# CITY OF ALBUQUERQUE

**Re: M&M Smoke Shop**  
**1800 Central SE**  
**Traffic Circulation Layout**  
Engineer's/Architect's Stamp **6-10-16** (K15-D100)

**Re: M&M Smoke Shop**  
**1800 Central SE**  
**Traffic Circulation Layout**  
Engineer's/Architect's Stamp **5-26-16** (K15-D100)

Based upon the information provided in your submittal received 5-26-16, the above referenced plan cannot be approved for Building Permit until the following comments are addressed:

SP-1

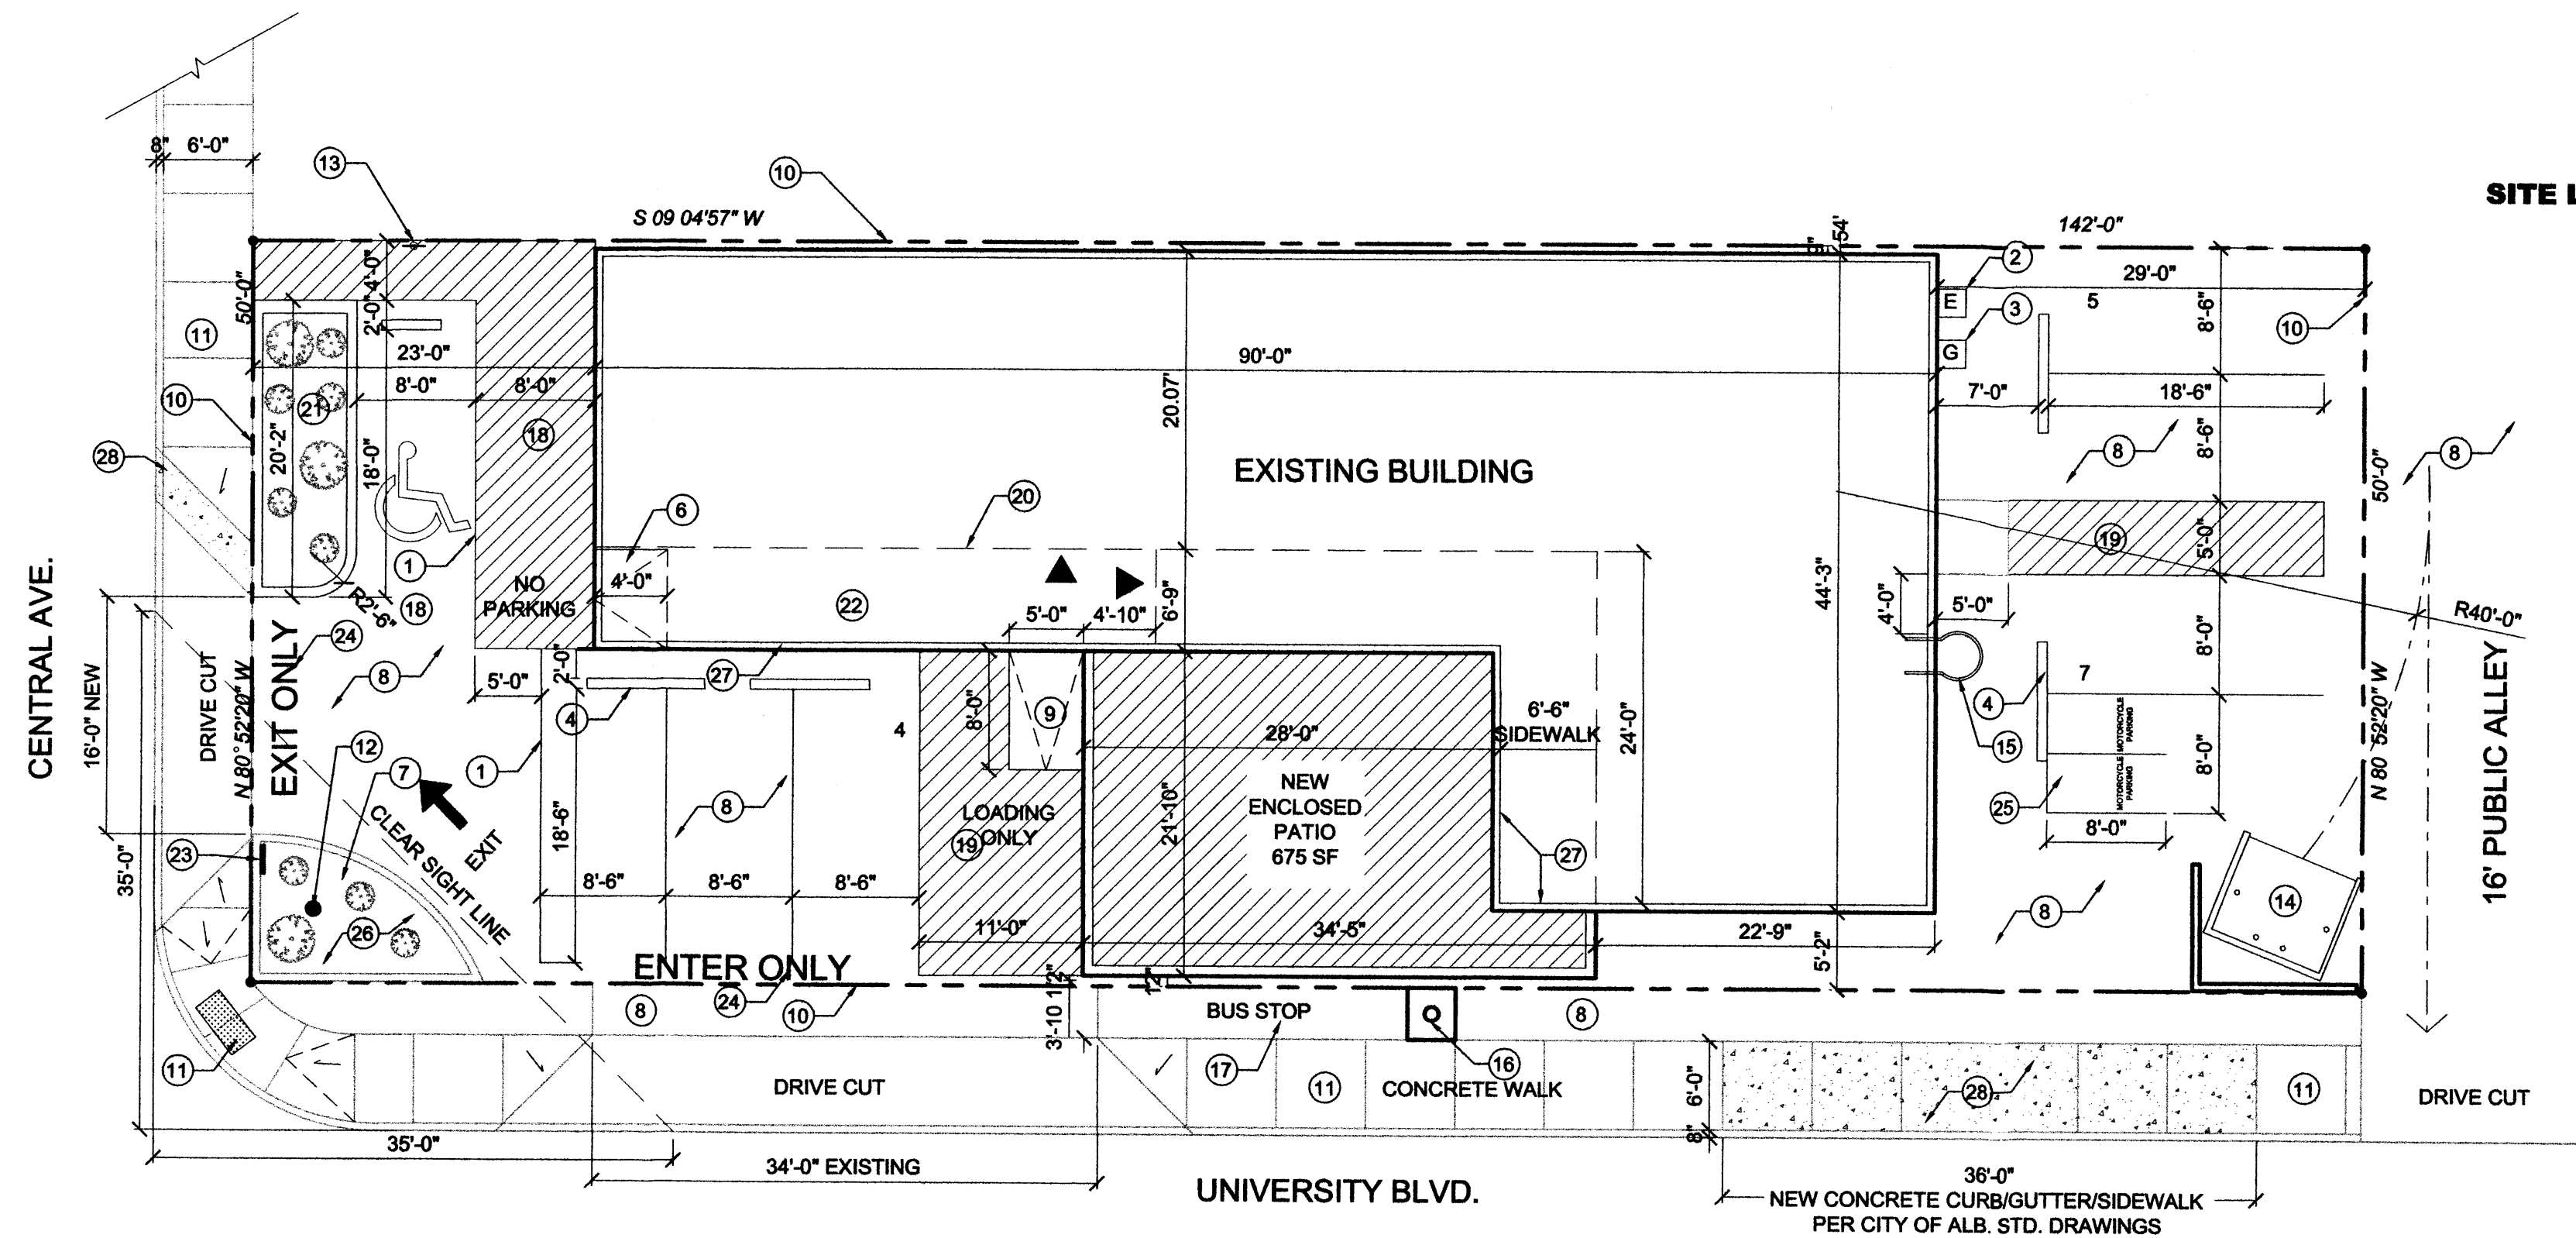
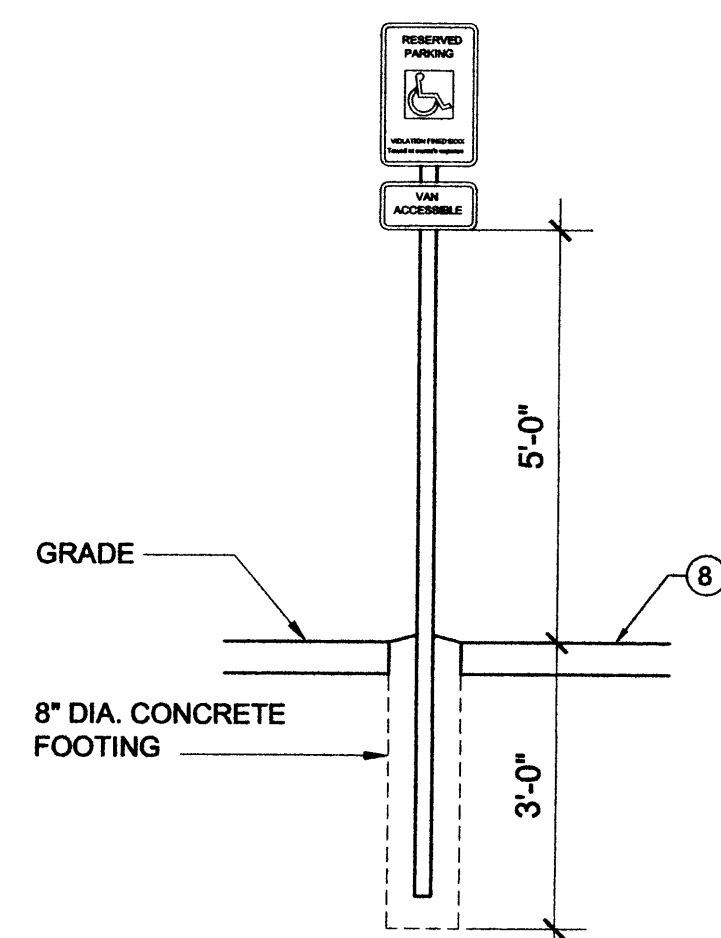
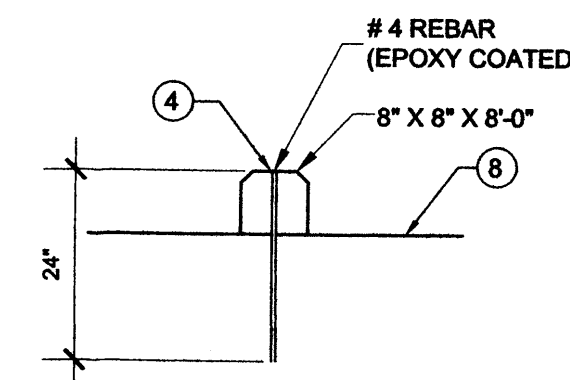
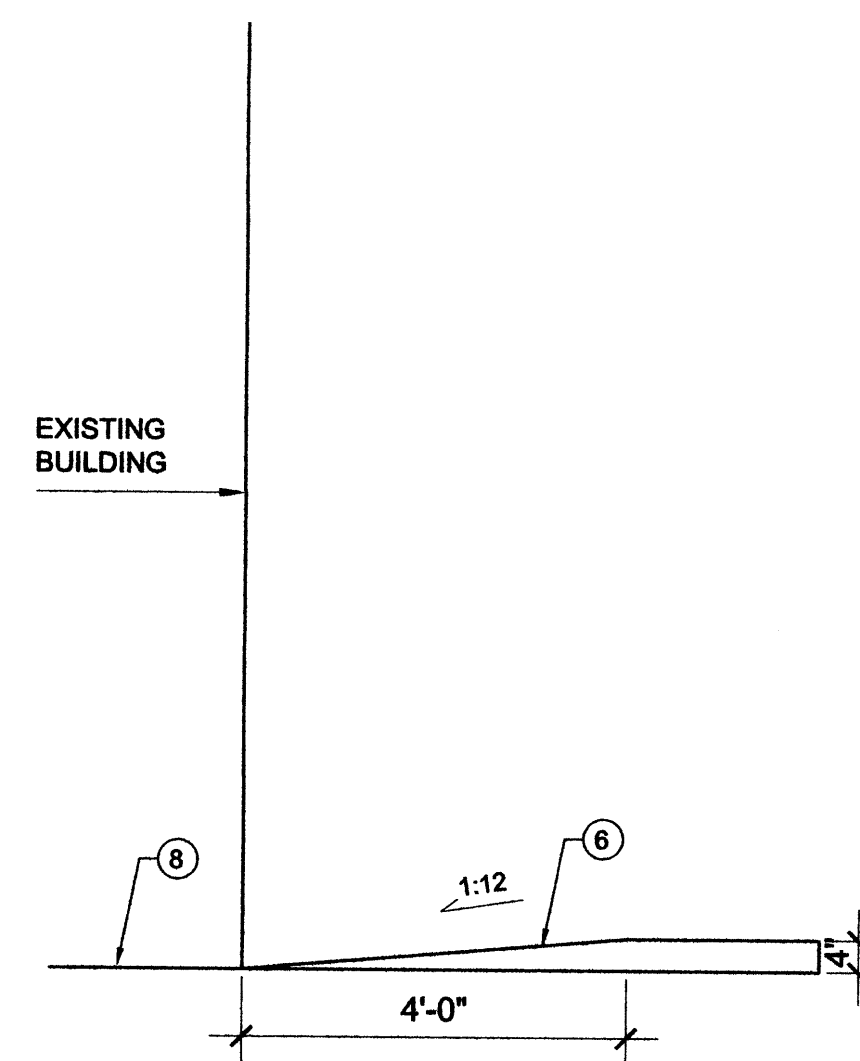
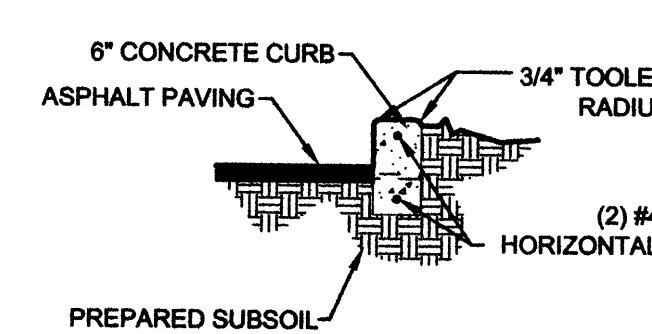
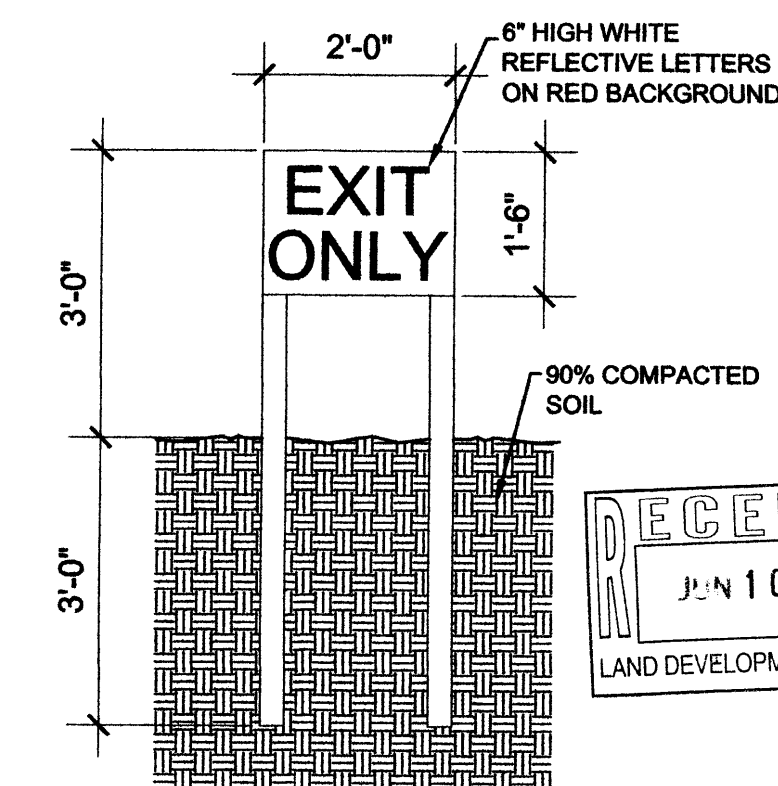
1. Please show a vicinity map showing the location of the development in relation to streets and well known landmarks.
2. List the number of parking spaces required by the zoning code as well as the proposed number of parking spaces.

7. The ADA accessible parking sign must have the required language per 66-7-352.4C NMSA 1978 **"Violators Are Subject to a Fine and/or Towing."** Please call out detail and location of HC signs. Please show this detail.

8. The ADA access aisles shall have the words **"NO PARKING"** in capital letters, each of which shall be at least one foot high and at least two inches wide, placed at the rear of the parking space so as to be close to where an adjacent vehicle's rear tire would be placed. (66-1-4.1.B NMSA 1978)

15. Please provide a sight distance exhibit (see the *Development Process Manual, Chapter 23, Section 3*). Please show detail from the exit/entrance off of the public alley.

16. Please add the following note to the clear sight triangle: "Landscaping and signage will not interfere with clear sight requirements. Therefore, signs, walls, trees, and shrubbery between 3 and 8 feet tall (as measured from the gutter pan) will not be acceptable in this area."

17. Unused curb cuts must be replaced with sidewalk and curb & gutter. A build note must be provided referring to the appropriate City Standard drawing. The curb cut on the south west side of building must be removed and replaced with COA standard curb and gutter.

18. It is not permissible for vehicles to back out onto University Blvd. from the parking stalls. Please provide and detail signs and pavement markings stating direction of exit.

The TCL submittal received 6-10-16 is approved for Building Permit. A copy of the stamped and signed plan will be needed for each of the building permit plans. Please keep the original to be used for certification of the site for final C.O. for Transportation.
